Recommendation Report for Planning Permission for Works or Extension to a Dwelling

REF NO: BR/158/19/PL

LOCATION: Flat 1
4 Nelson Road
Bognor Regis
PO21 2RY

PROPOSAL: Proposed front extension

Proposed South Elevation

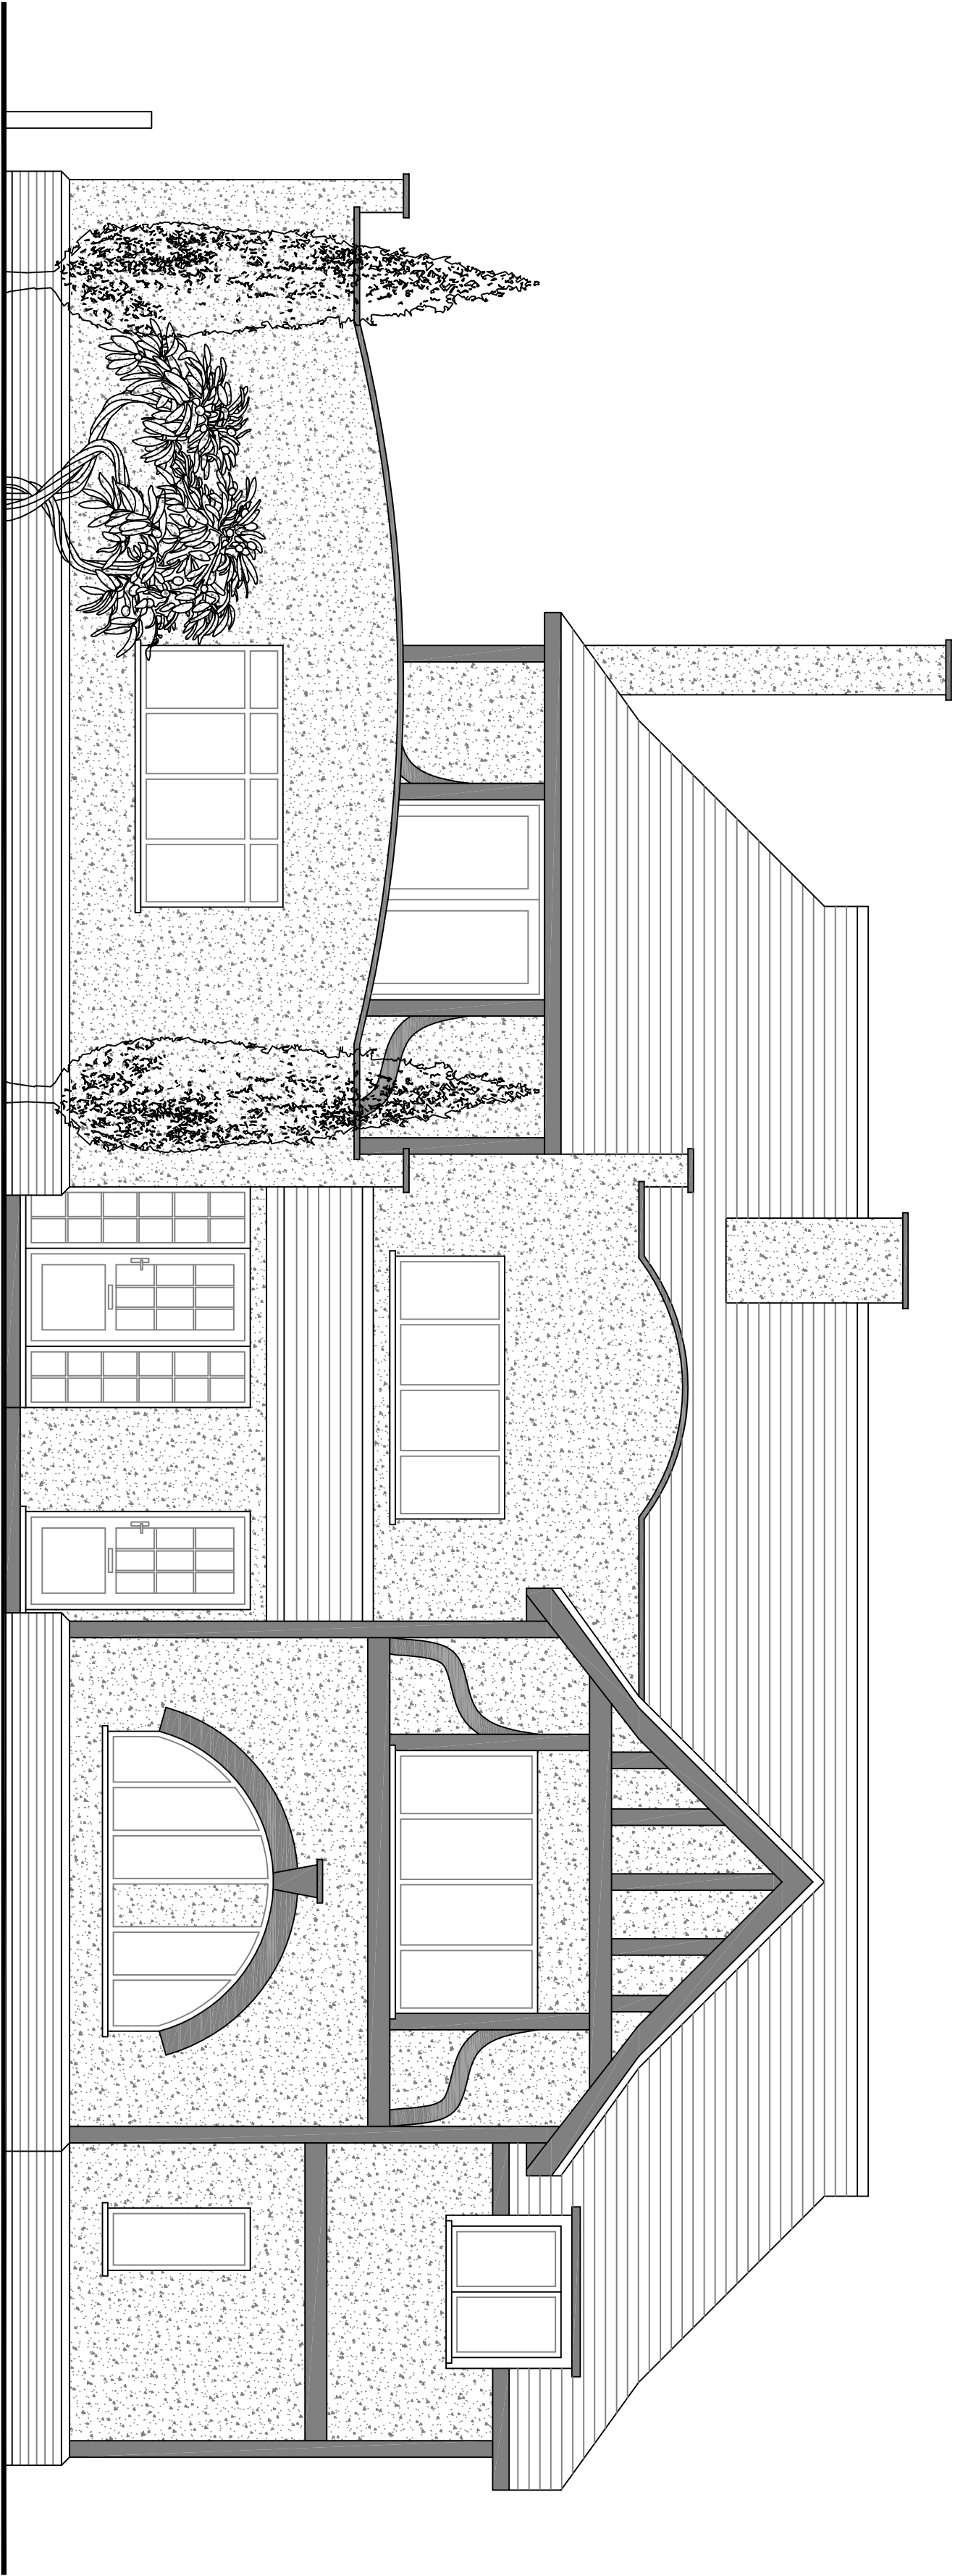
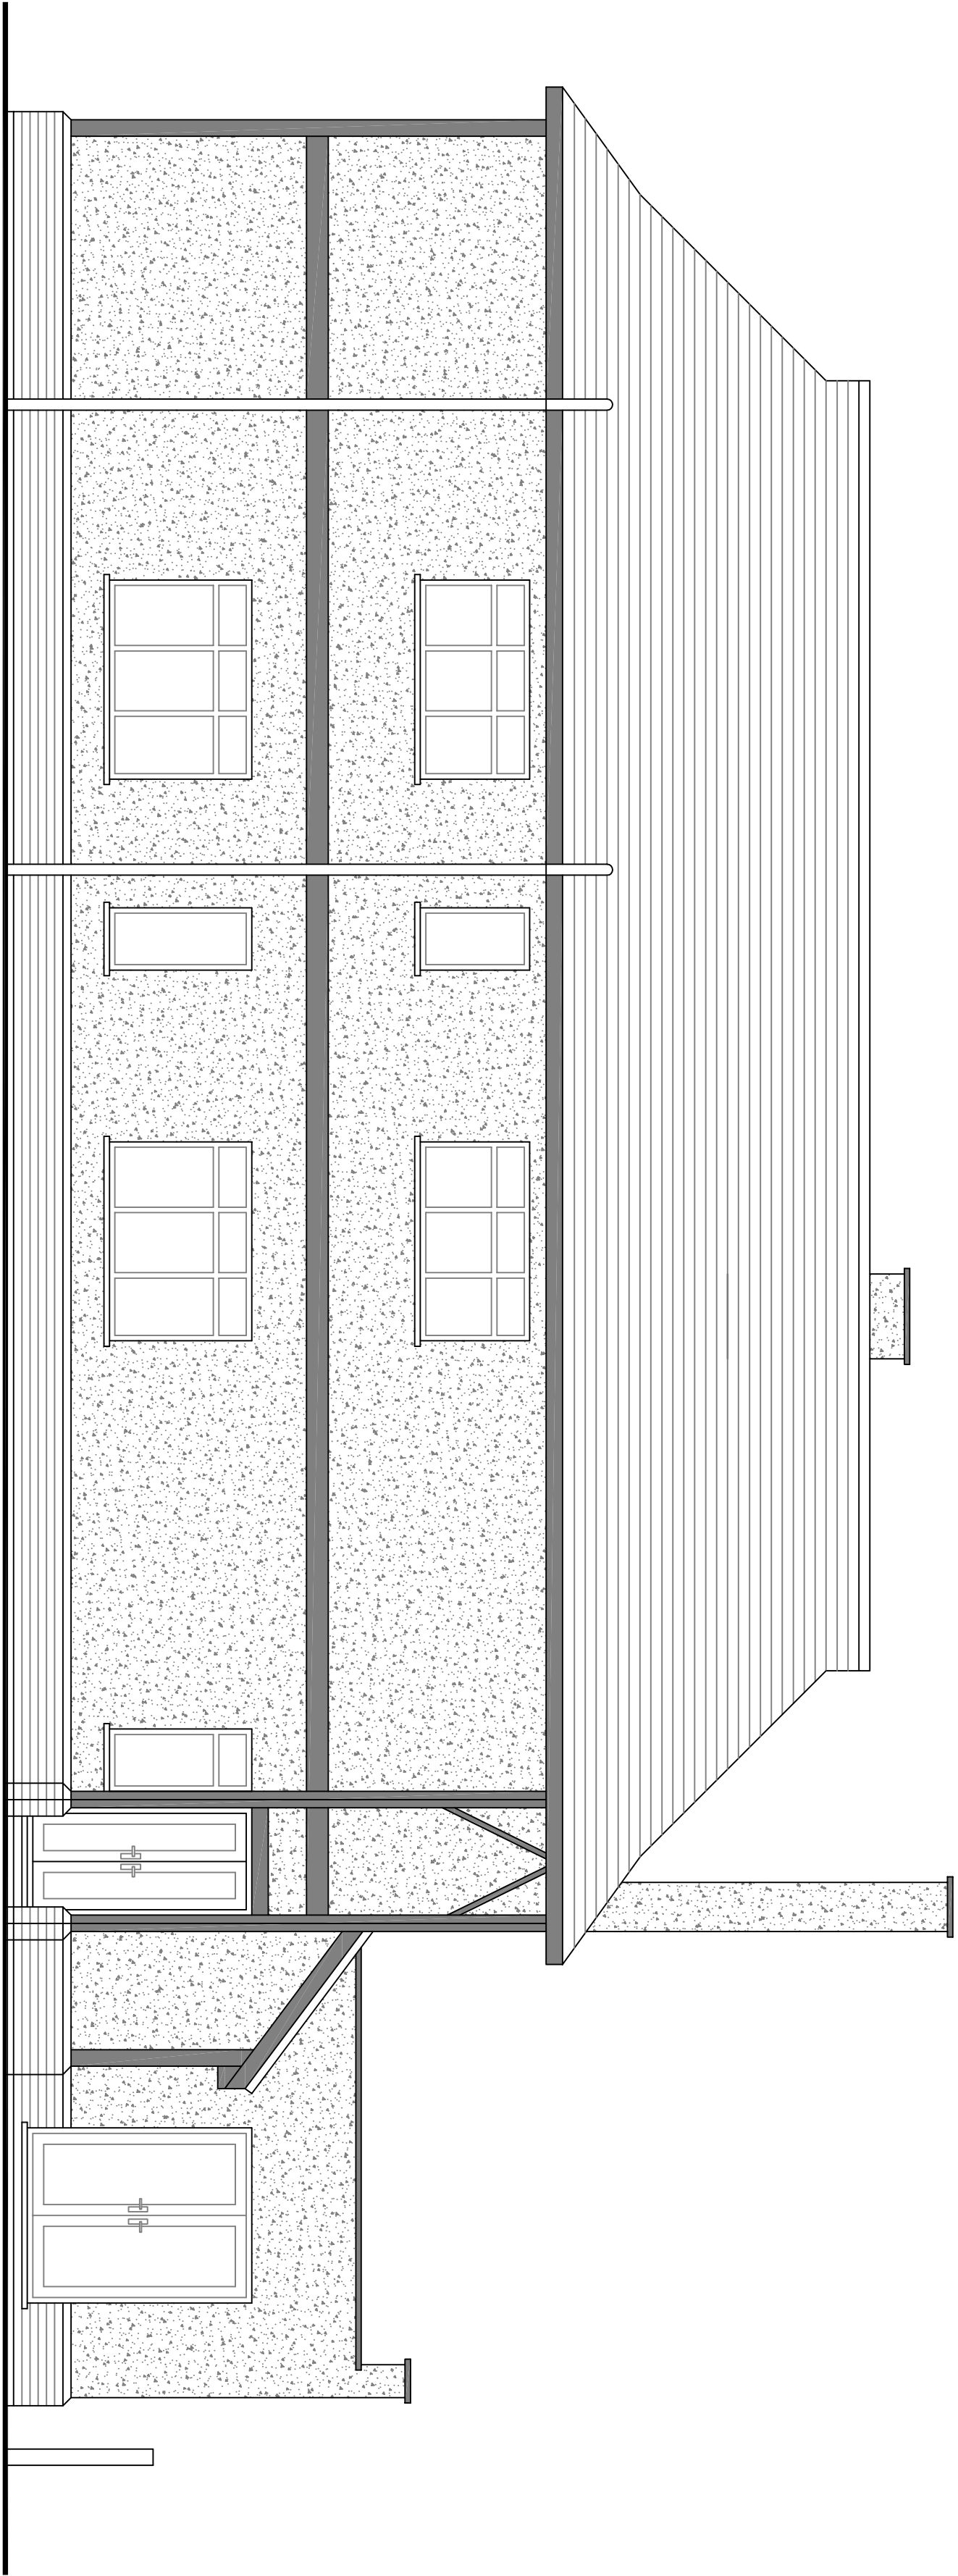
1 window is proposed to the south and 1 to the east. These are not deemed to give rise to adverse overlooking, with views predominately over the street scene and 15m to the eastern boundary fencing.

Proposed West Elevation

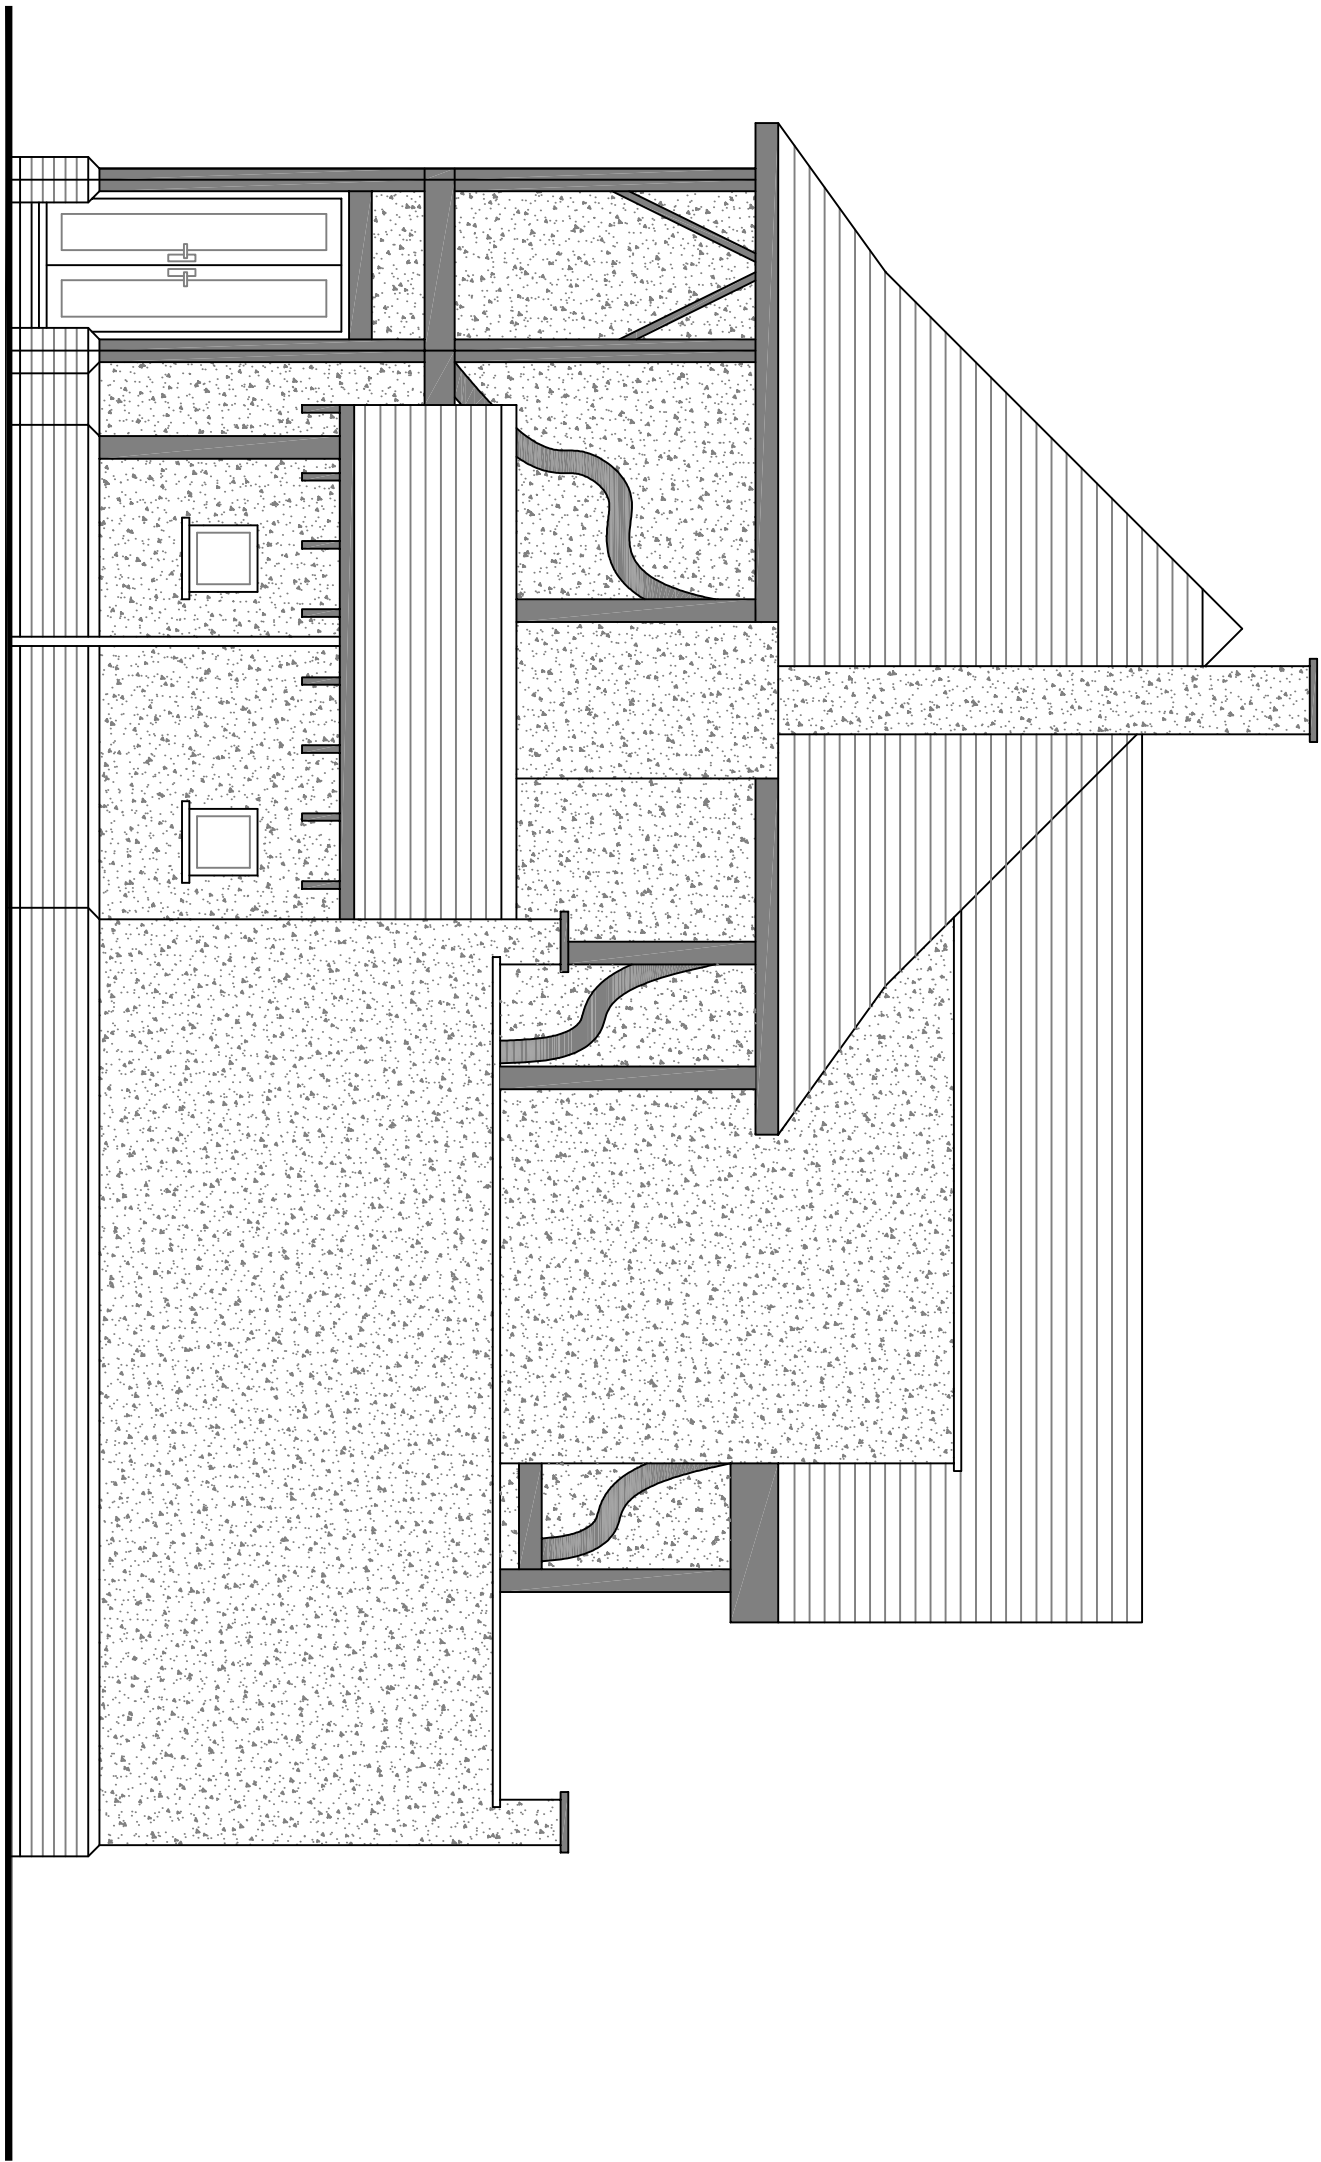
Whilst the extension is a large addition it appears subservient to the host dwelling. It has been constructed to appear sympathetic in appearance to the host dwelling with the roof constructed with a slight curve to match the design style of the host dwelling and with the use of matching materials.
